KIRKLEES DISTRICT COUNCIL

Planning application number 2023/90956 by P O’Kane relating to the site at the rear of Sparks Road for the erection of 5, 3 bed dwellings.

We are instructed by Heathcote Transport Limited. Please accept this letter as representations on their behalf in respect of planning application number 2023/90956 (the ‘Application’) by P O’Kane (the ‘Applicant’) relating to the site at the Rear of Sparks Road (the ‘Site’), for the erection of 5, 3 bed dwellings (the ‘Development’).

2. Existing Site Layout
Scale 1:500

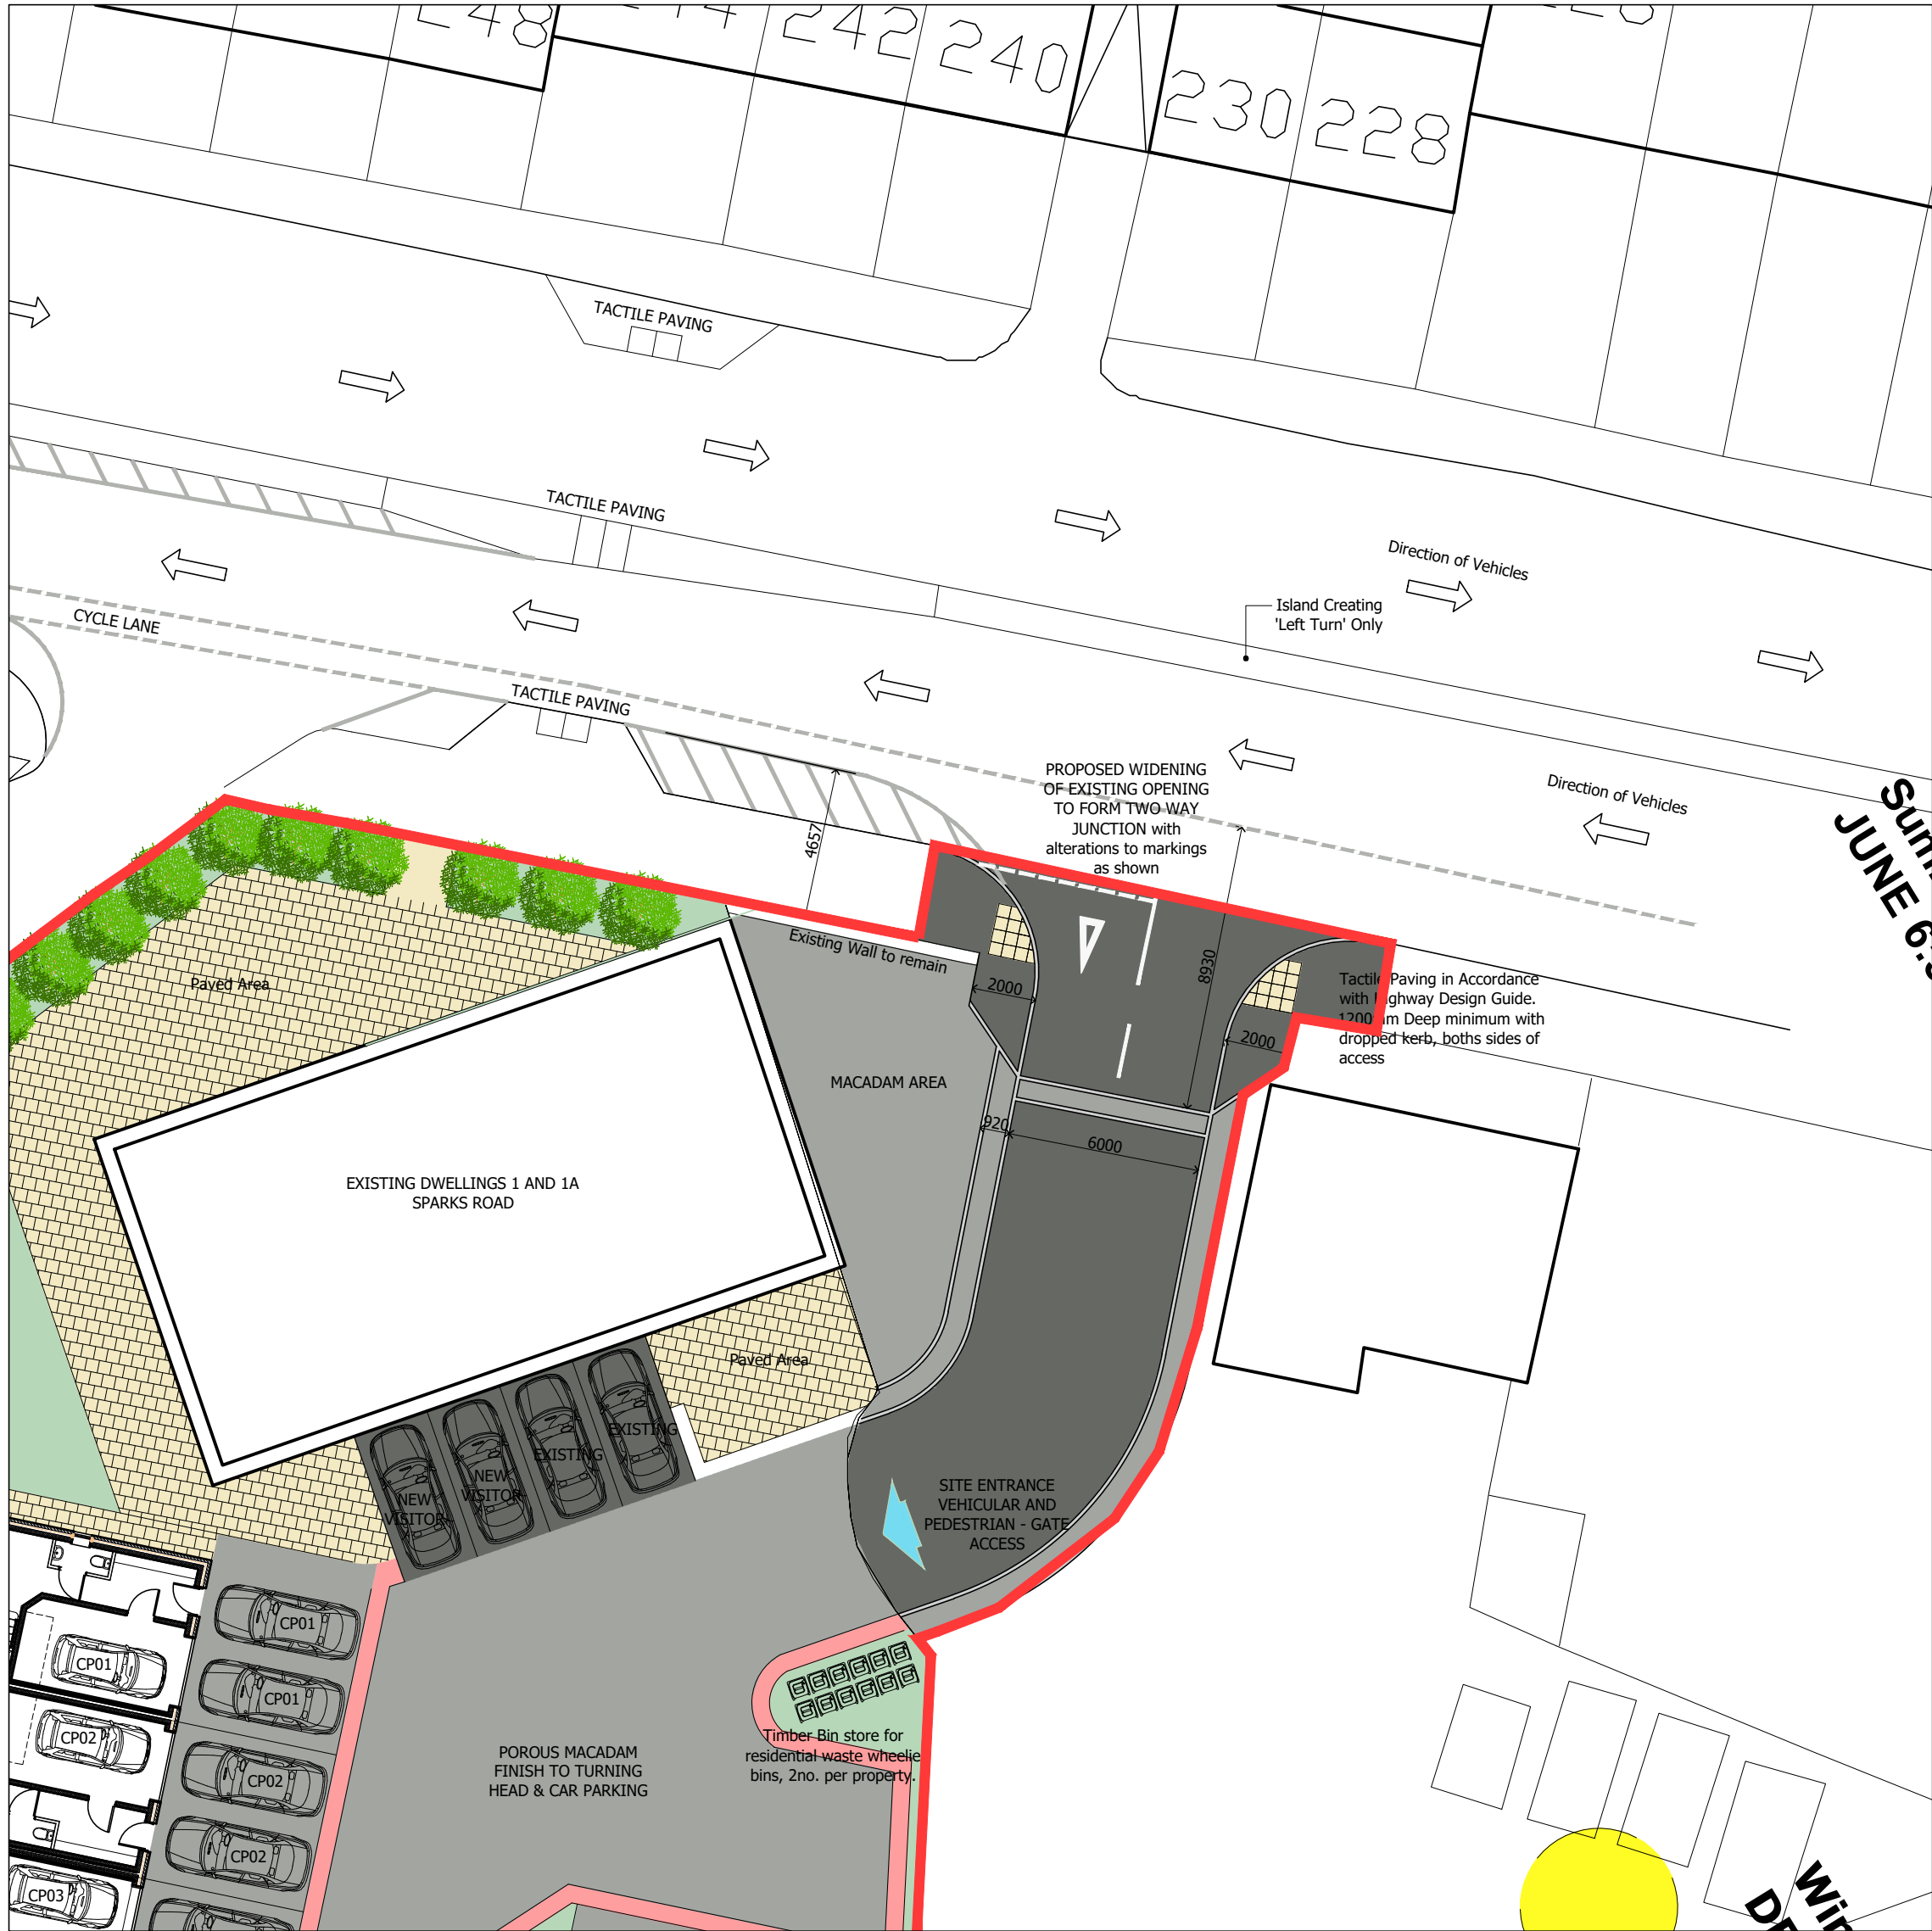
- 3.1 The Development proposes an improved junction with New Hey Road. Plan 22216.01 Rev B Nov 22 shows '*proposed widening of existing opening to form two-way*

junction'. A proposed width of the entrance at the junction with New Hey Road of 6000m with 2000mm either side is proposed and a note on the plan states '*Tactile paving in accordance with Highway Design Guide 1,200 mm. Deep minimum with dropped kerb both sides of access.*

3.2 To widen and improve the junction as proposed would require land included in the title registered to Mr [redacted] and no consent has been given or legal rights granted to allow this to happen. The Applicant cannot therefore widen the junction as proposed and for the same reasons given at 2.6 above planning permission should not be granted for this development when the Applicant does not have the right to construct the proposed junction.

3. Proposed Site Layout  
Scale 1:500

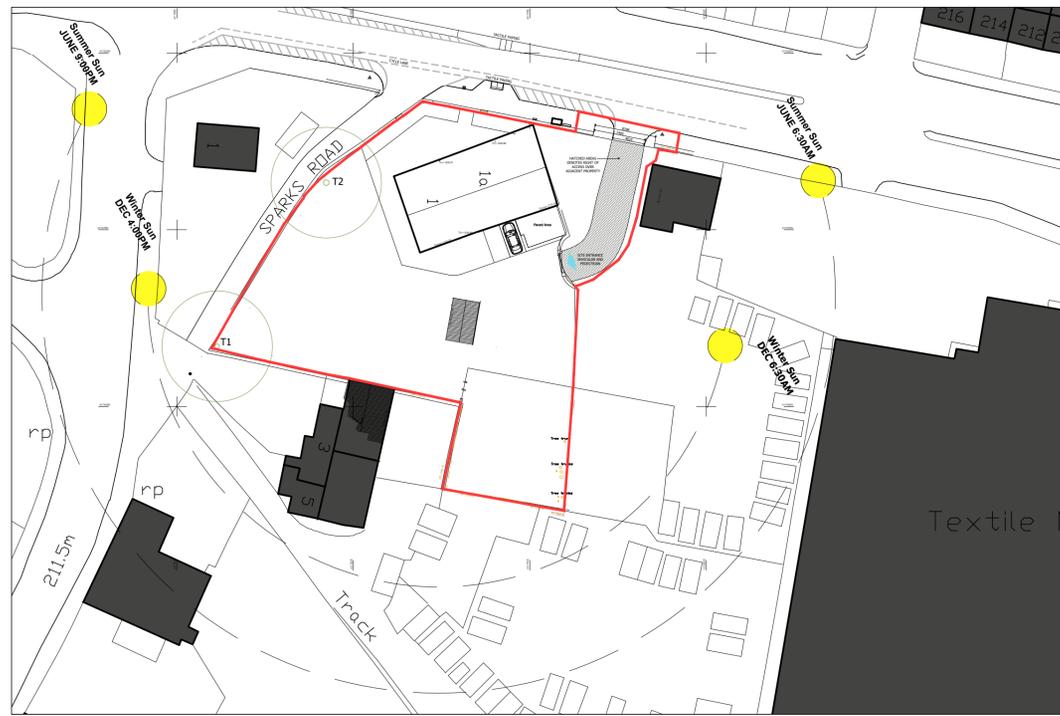
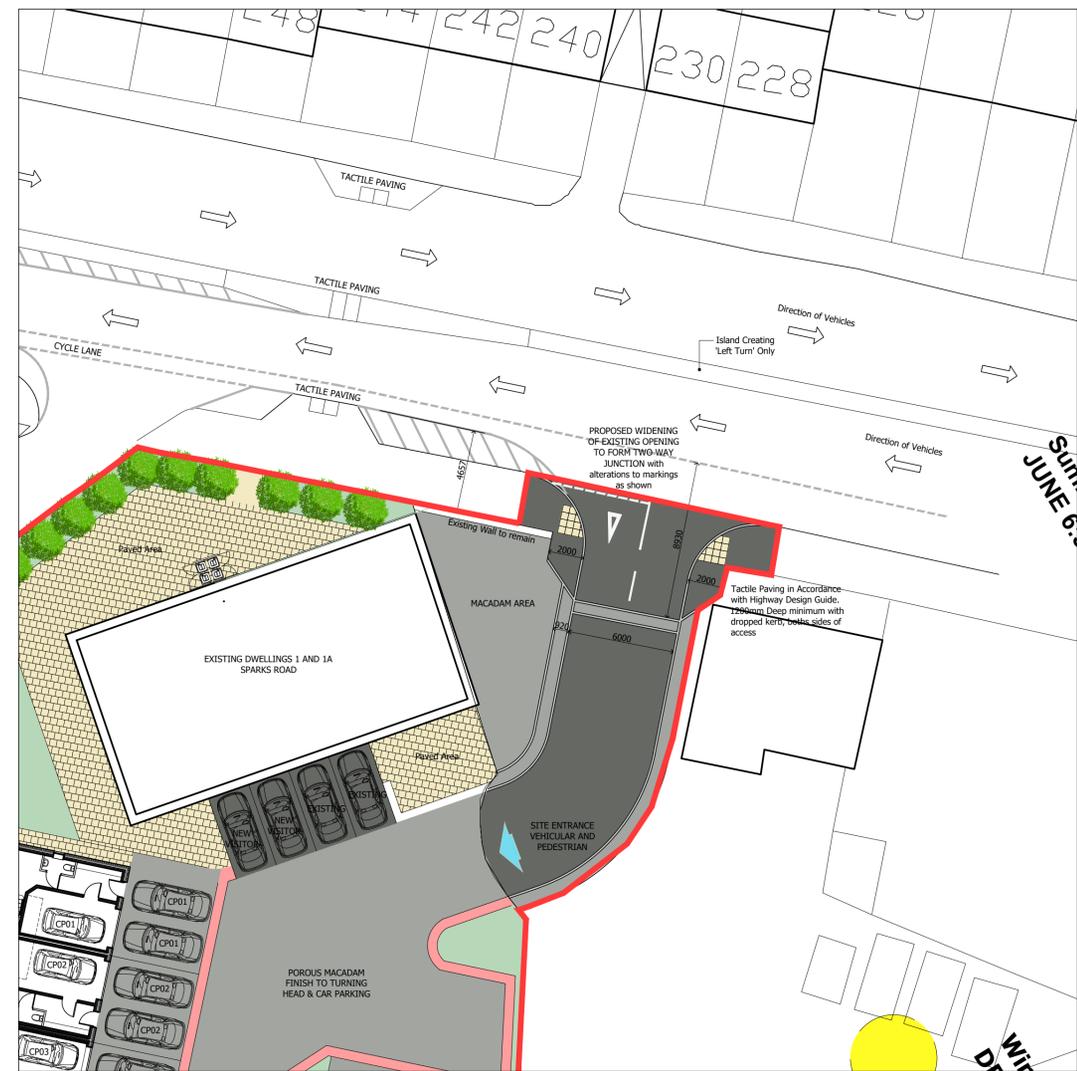
- 2.1 The access to the Development is proposed to be across land not in the ownership or control of the Applicant.
- 2.2 Plan 22216.01 Rev B Nov 22, submitted with the Application, shows access details. This includes a location plan and existing site plan both showing '*hatched area denotes right of access over adjacent property*' The plan also shows the proposed width of the proposed access as 6,000mm with a 920mm path on either side.

- 2.4 Whilst the Applicant does have a right of way across the Third-Party Land, its width is defined on the registered title plans and it is not wide enough to accommodate the proposed access. The Applicant does not therefore have sufficient legal rights to implement the access as proposed.

4.1 The Design and Access statement states '*....parking is also possible and occurs to the parcel of land directly adjacent number 1a sparks road and between the access into the haulage yard. This space will be resurfaced and allocated as parking for visitors of the development and the haulage yard.*' Plan 22216.01 Rev B Nov 22 shows the notation '*Macadam Area*' in this location.

4.2 The area referred to in 4.1 above is on the Third-Party Land. The Owners have not consented to the proposal and no legal rights exist for the resurfacing of this area and its allocation for parking.
